RE Demolition of existing structures on-site & erection of 42 No. dwellings with access, parking, landscaping and associated works. This application is a departure from the development plan.

I am writing to you in connection with the above development following recent comments to discharge conditions 10, 11 and to confirm further details relating to condition 20. Following an email from our engineer, I copy their response below again to formally submit the information.

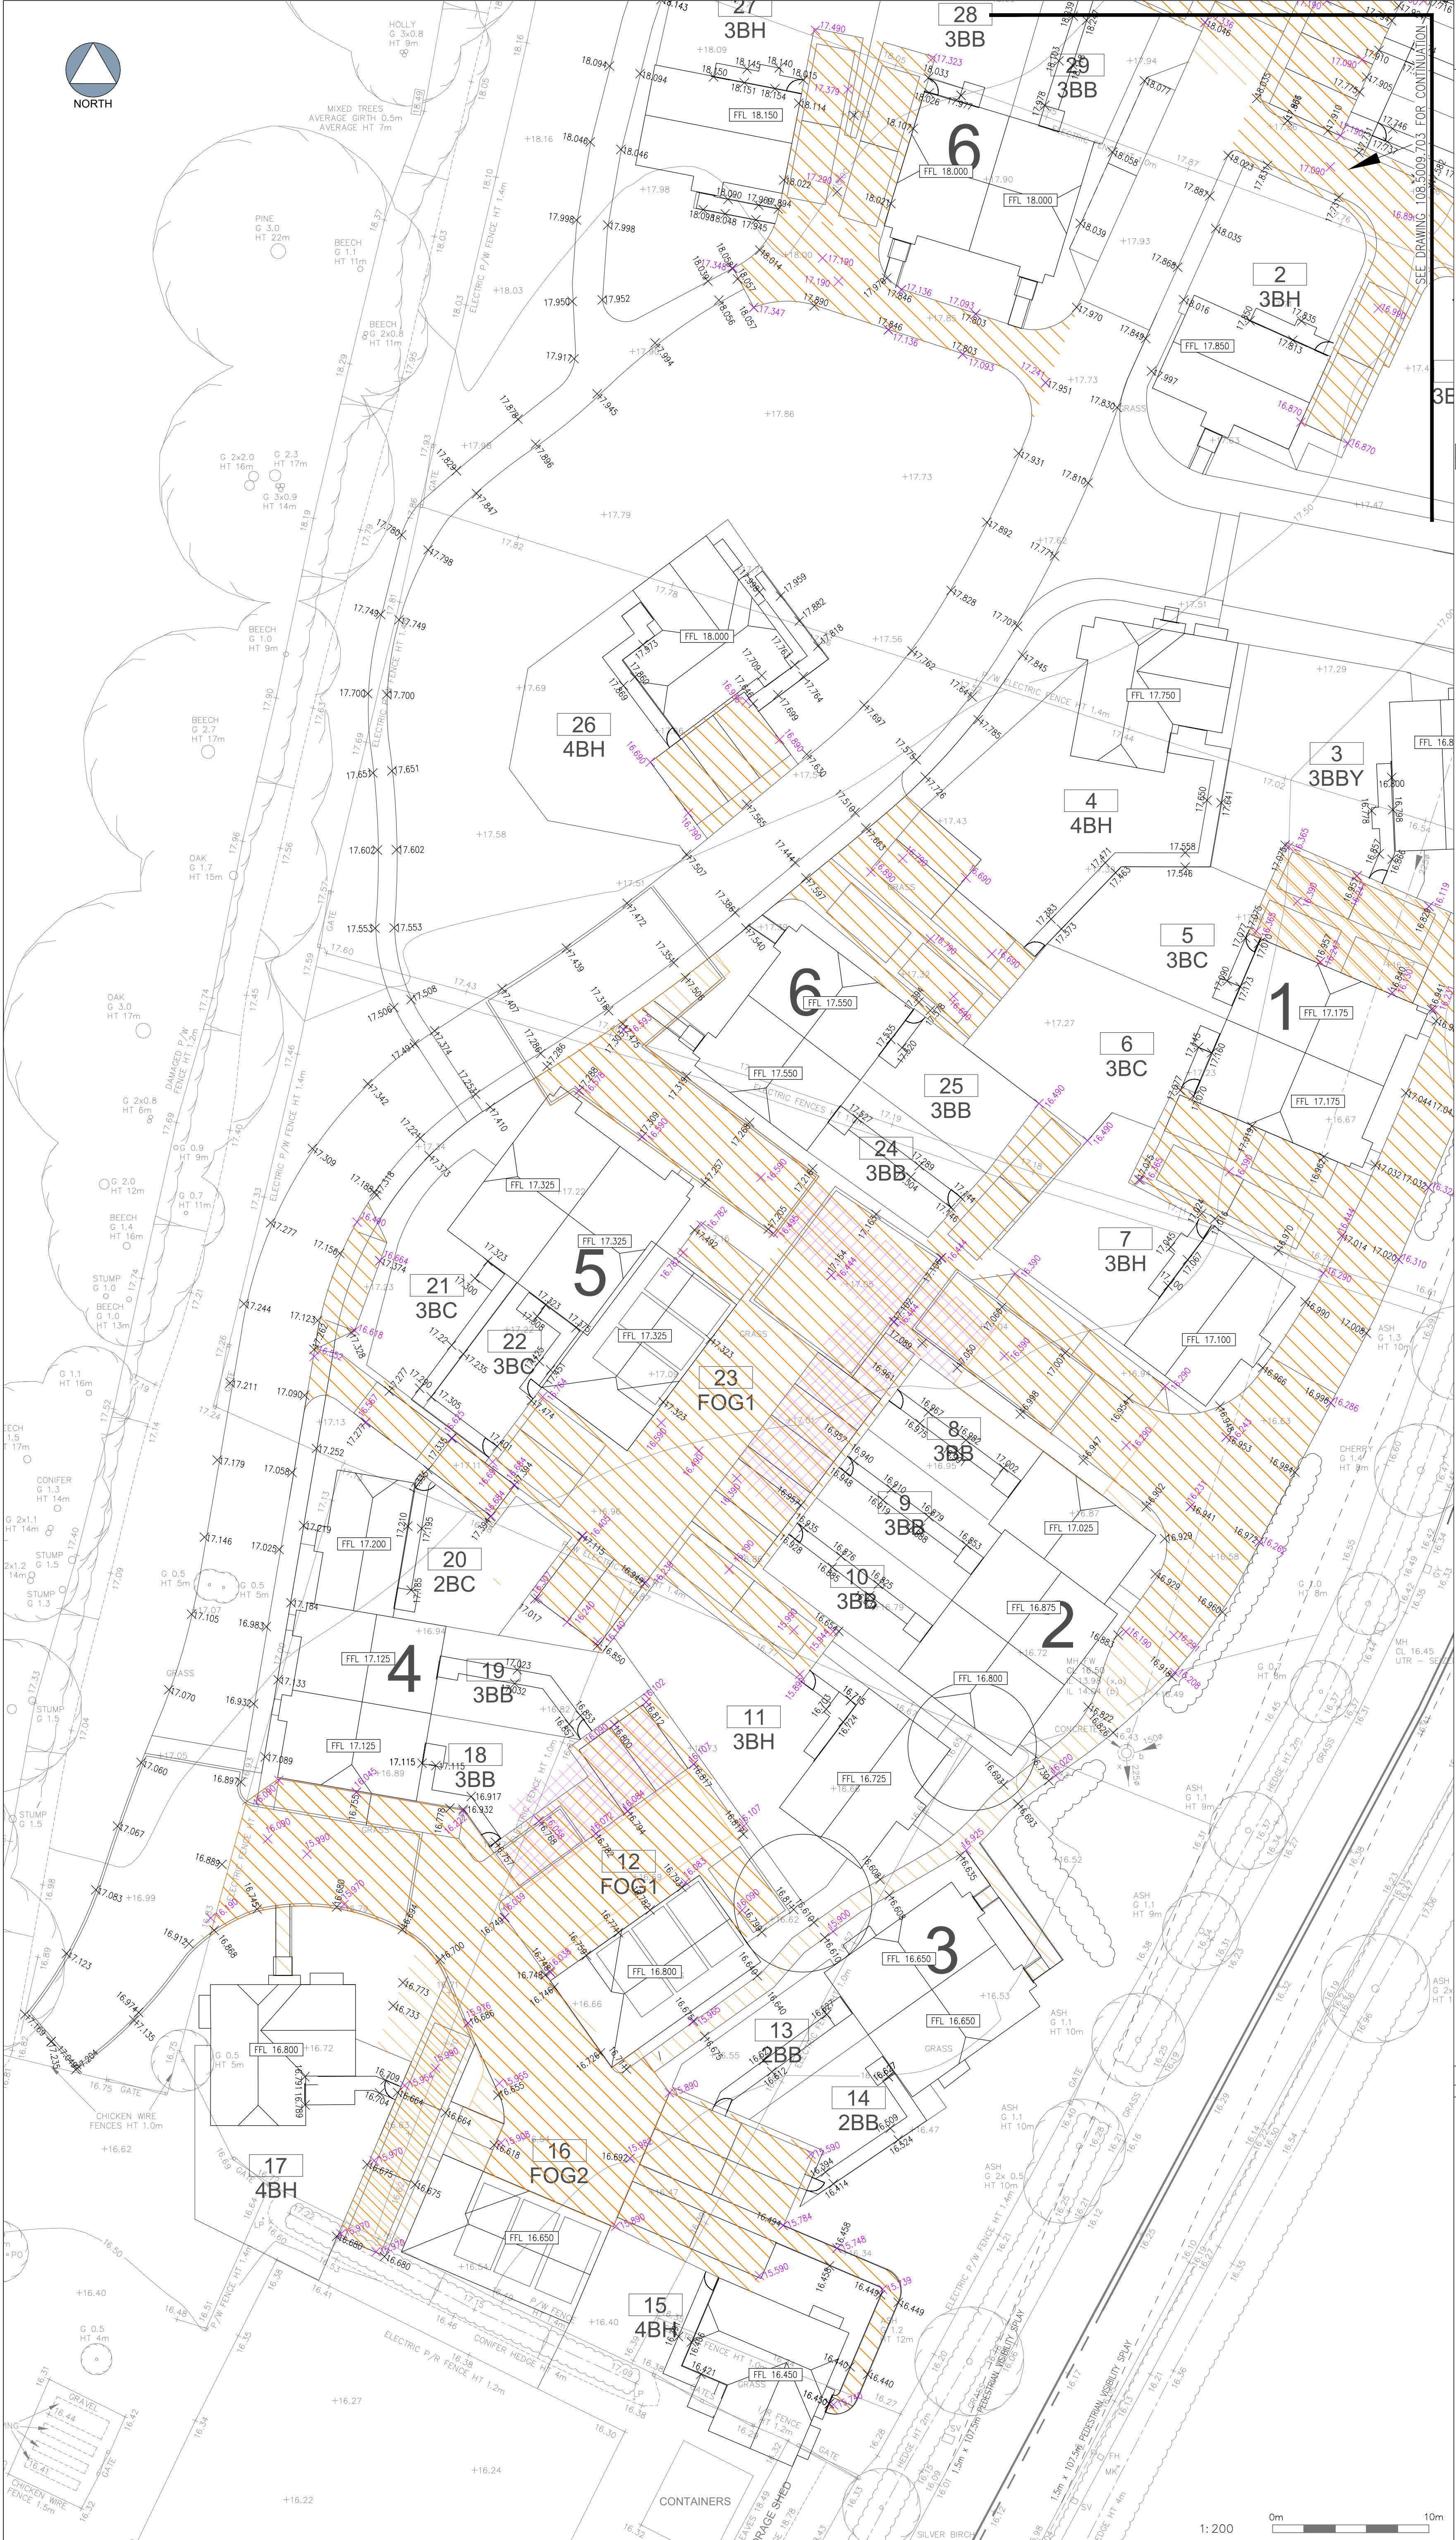
5. Finish and formation levels of permeable paving must be detailed.

The full details of the permeable paving are shown within drawing 751. Drawings 501-506 have been updated to show the construction of the permeable paving within the key. Please also refer to drawing 705 and 706 for full details on the external finishes. Drawings 704 and 703 have now been provided which detail formation levels.

CONSTRUCTION		Checked Date		Drawn By		Drawn Date	
RW		07.05.21		RD		07.05.21	
Client Drawing No.		-		Scale		1:100 (AT A1 SIZE)	
PBA Drawing No.		108.5009.504		Revision		E

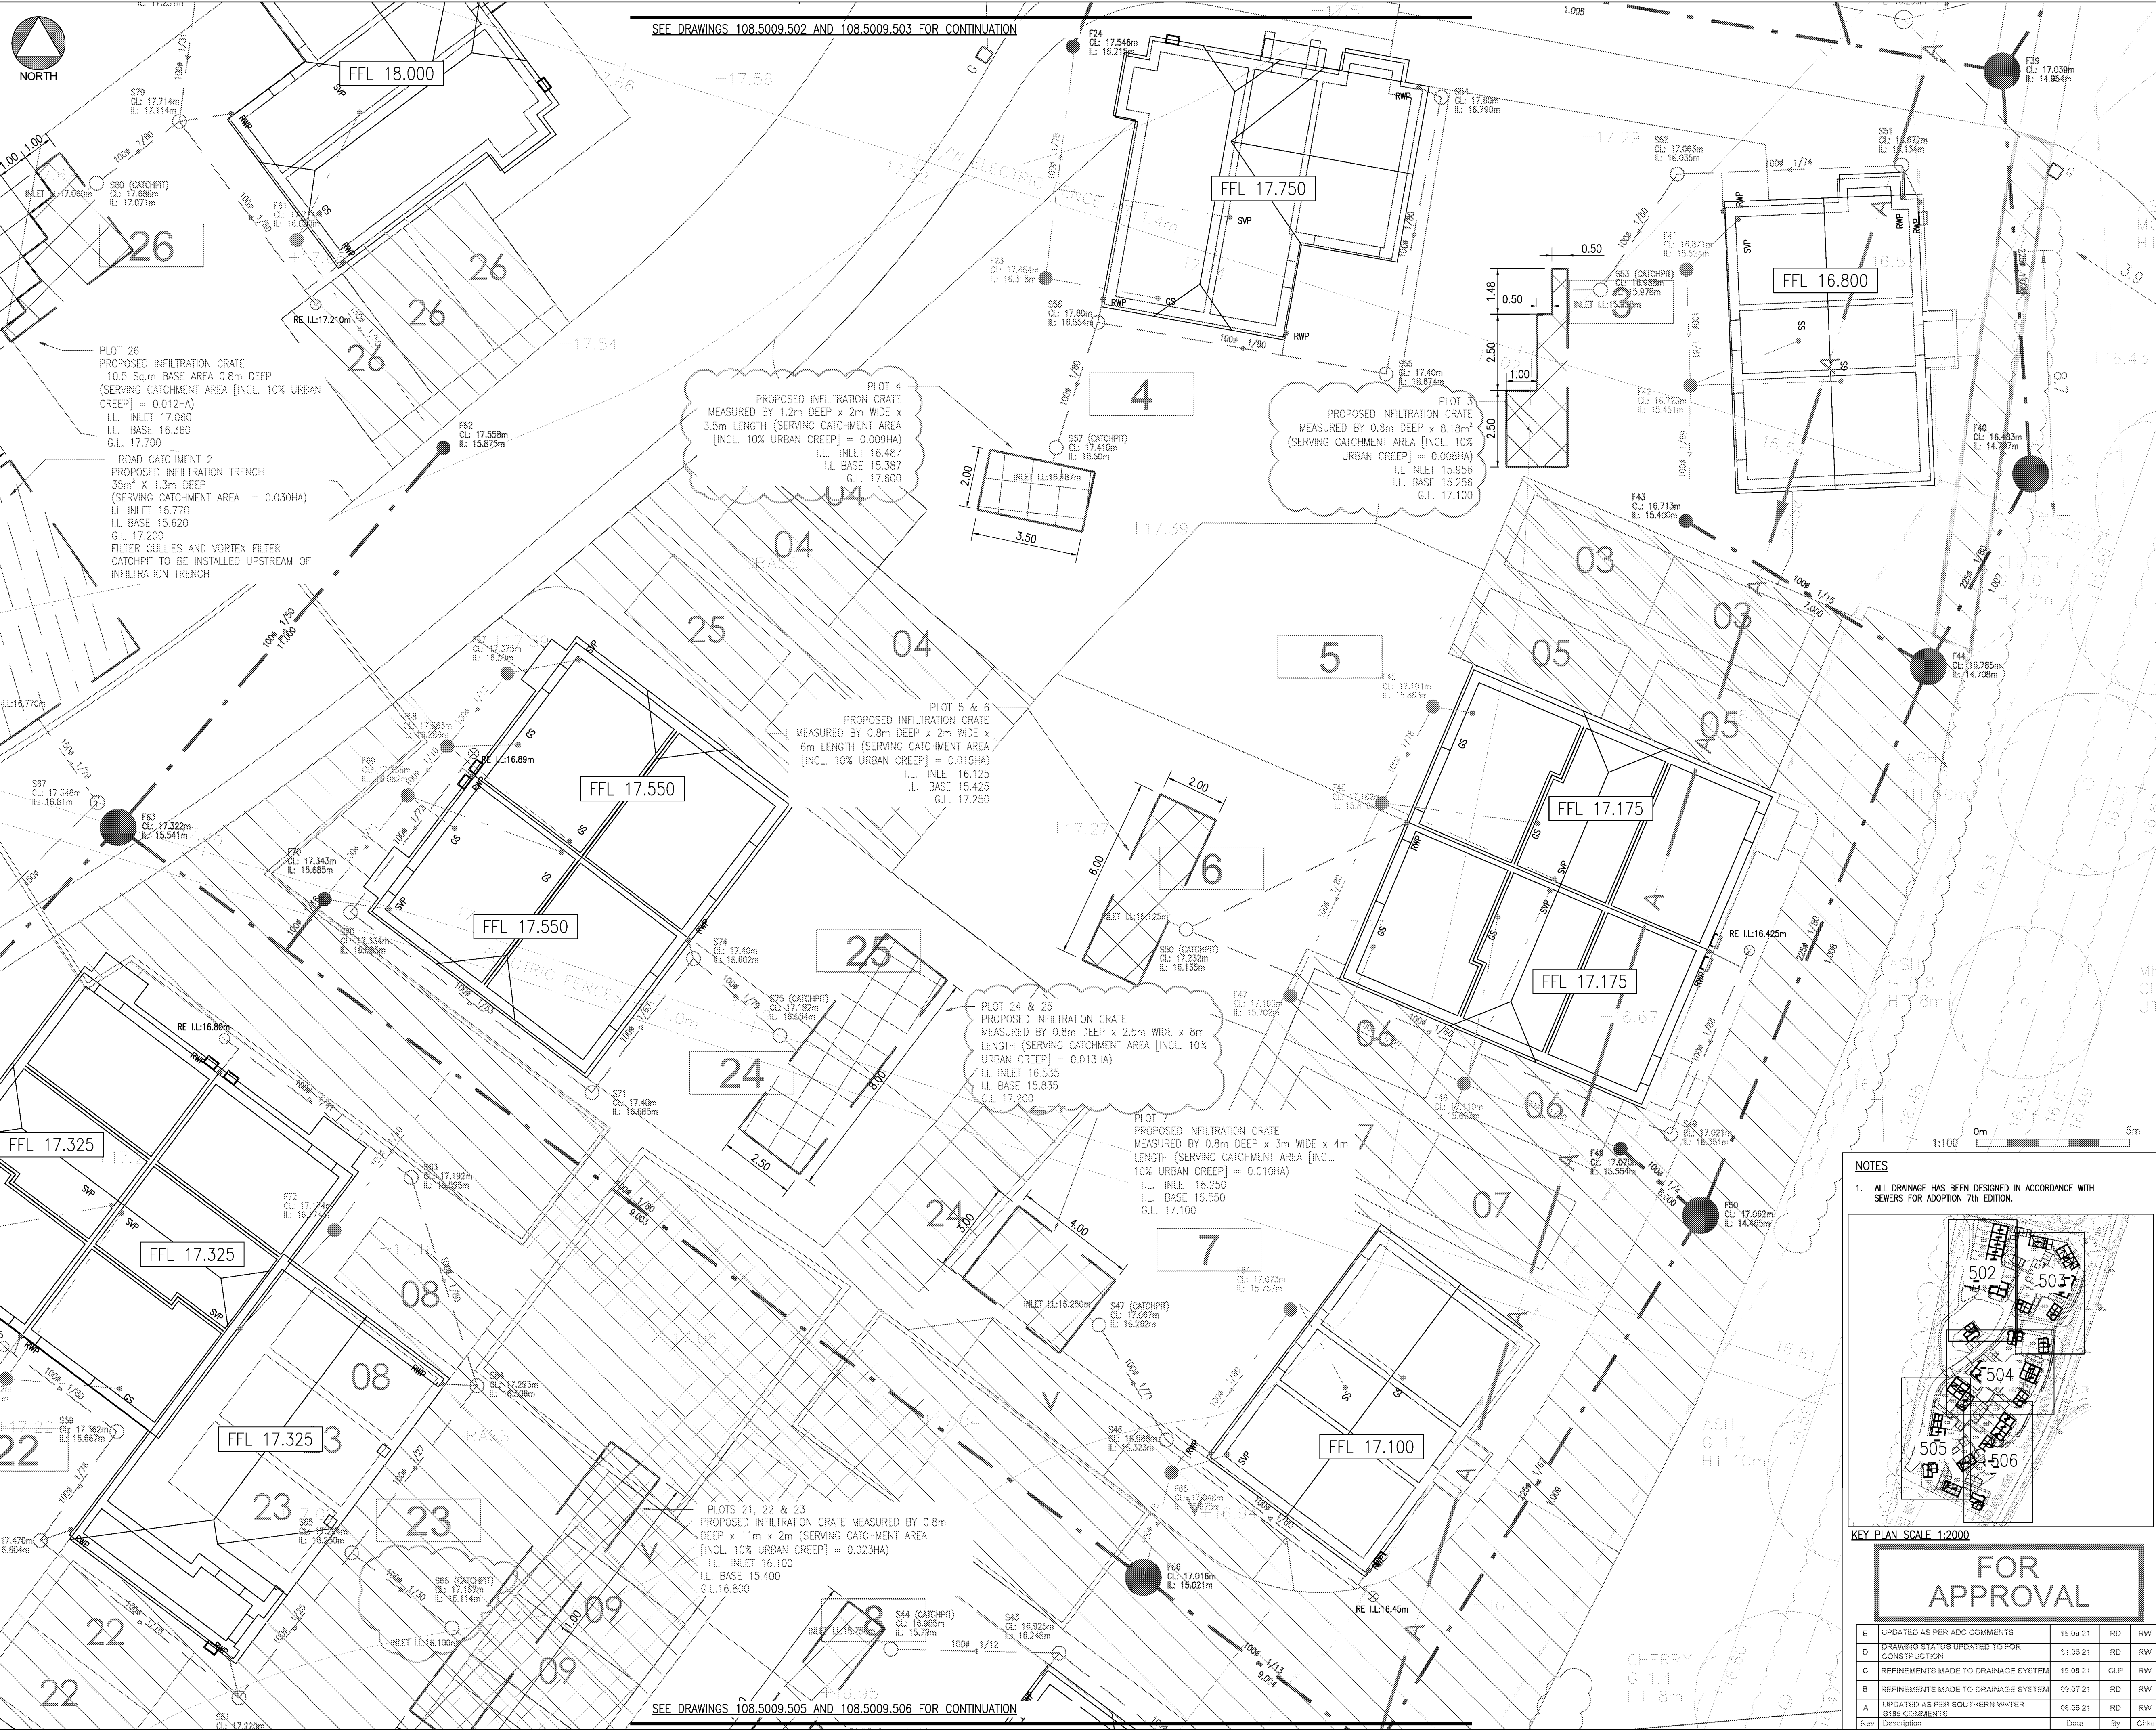
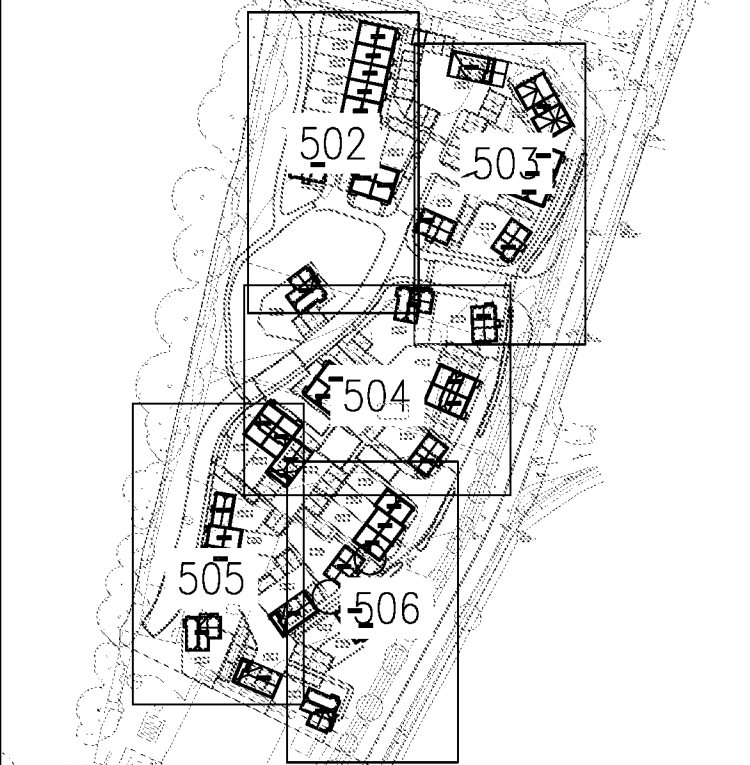
1. Catchpits must be provided upstream of all connections into soakaways. Please clearly show these on plan

2. Detailed drainage layout plans must show crate dimensions, i.e. length, width, depth, invert level, incoming invert level and cover level.

9. Incoming invert levels for soakaways for plots 3 and 4 are inconsistent between drawing 501 and 504. Invert levels on 504 are below 1 in 10 year plus 40% cc water levels.

12. Incoming invert levels for soakaway for plots 24 and 25 is inconsistent between drawing 501 and 504.

Catchpit annotation has now been added to drawings 502-506.

Drawings 502-506 updated to show crate dimensions.

(9-12) The invert levels of the catchpits upstream of the infiltration crates have been amended to ensure that they fall at no steeper than 1:30 into the crates.

PBA Drawing No.	Revision
108.5009.505	E

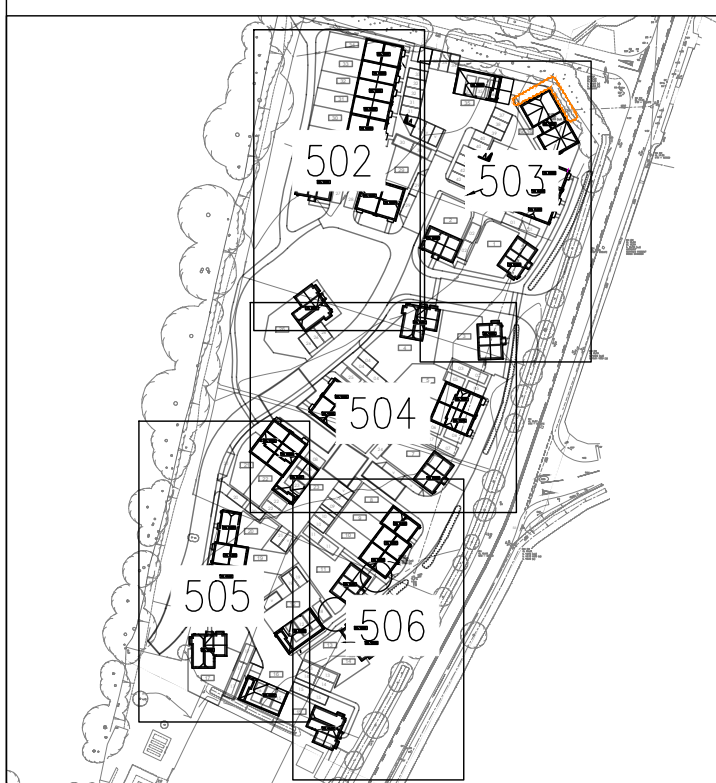
10. Incoming invert levels for soakaway for plots 16 and 17 are inconsistent between drawing 501 and 505. 505 invert levels are above the top of crate level.
